Re. Application reference: 6/2021/2384/EM

Objections to Proposed Development

I wish to make you aware of a number of strong objections that I have with regard to the proposed development of an extension to the side of 31, Lemsford Lane, Welwyn Garden City ("No.31") application number referenced above.

Proposed Side Elevation

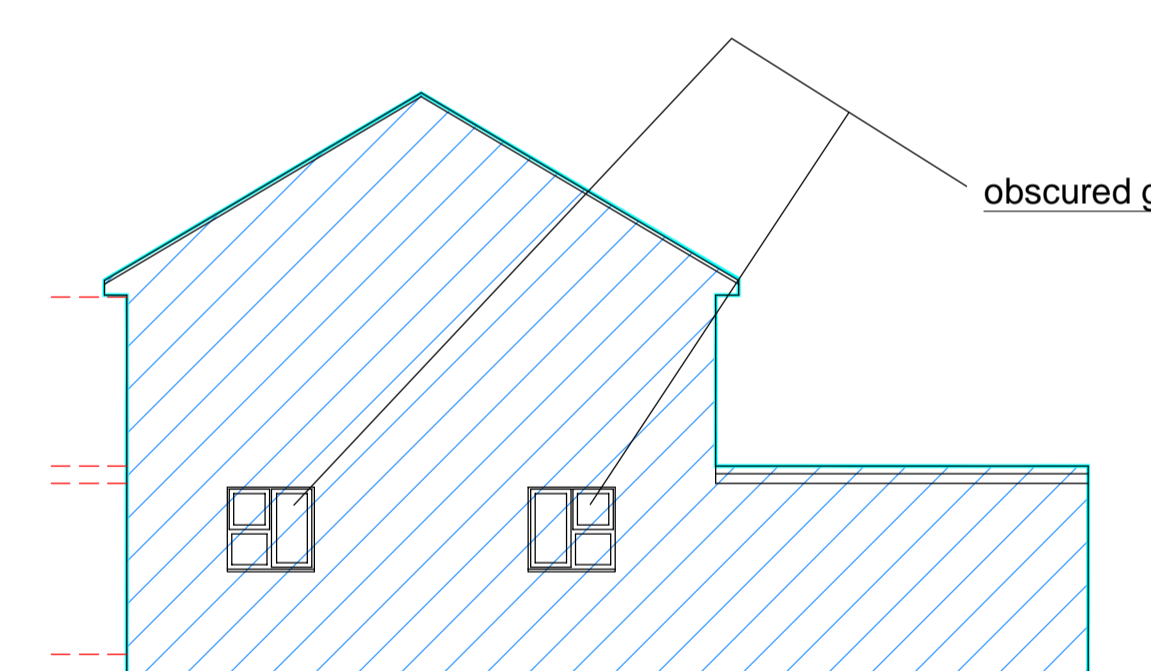
The proposed extension will put much of my property into shadow. The ground level of No 31 is a good meter or more above the ground level of the terrace which include No 23. This elevation means any height added to No 31 has an increased impact on my property. Additionally, as my property/No. 23 faces 143 degrees SE this means the shadow will be present for most of the day. I would therefore no longer have the current light/view that the Property has benefitted from to date, which I believe I have a right to.

Additionally, there are windows in my property where I currently have a view of the sky (e.g. my dining room window). My view, if this proposed development goes ahead, will be substantially of the wall. I think this will affect the value of my property and well as my well being.

If the proposed development was only a one storey extension, I think this could alleviate my concerns.
